**RE: Chick-fil-A at Gibson
1600 Gibson Blvd SE
Requested for Permanent C. O. - Accepted
Engineers Stamp Date 7/29/15 (M15D012C)
Certification dated: 12-22-15**

Based on the Certification received 12/22/2015, the Chick-fil-A is acceptable for permanent release of Certificate of Occupancy by Hydrology.

RE: **Chick-fil-A at Gibson**
1600 Gibson Blvd SE
Grading and Drainage Plan
Engineers Stamp Date 4/27/15 (M15D012C)

RE: **Chick-fil-A**
1600 Gibson Blvd SE
Grading and Drainage Plan
Engineers Stamp Date 3/18/15 (M15D012C)

C-3.0

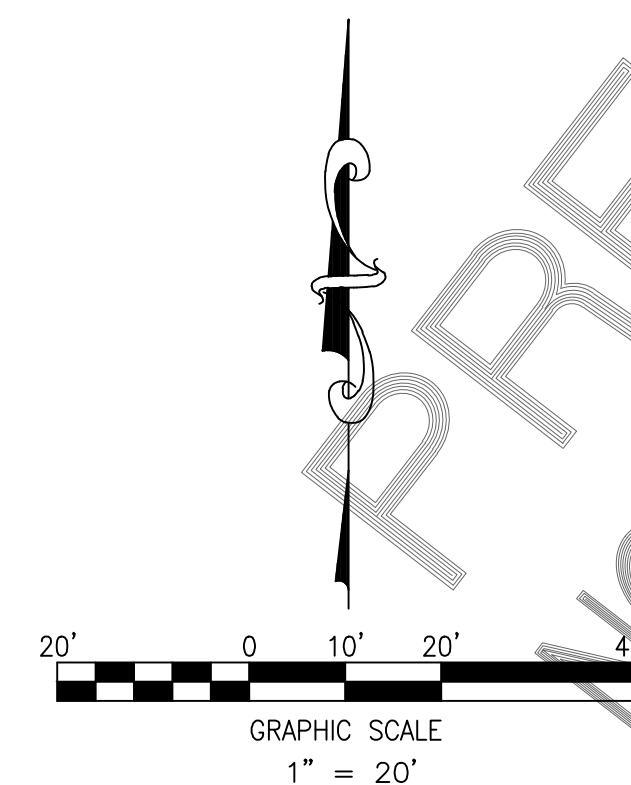
- d. Provide a connection detail to the 21" storm drain.
2. Verify Pond Bottom Elevation is 92.00 (Sht C3.0). It appears that it needs to be lowered since the invert is at 91.43(Sht C3.3).

3. There is an existing storm drain and inlet just north of the proposed storm drain. Please indicate if these items are to be removed or will remain.
4. Since the pond is intended to drain via the existing storm drain, be sure to note it as a detention pond.

Response: See revised plans.
 - Provide connection detail to the 21" HDPE storm drain.
Response: See revised plans.
 2. Verify Pond Bottom Elevation.
Response: Typo was on the plans. Plans have been revised.

Response: See revised pond callout.
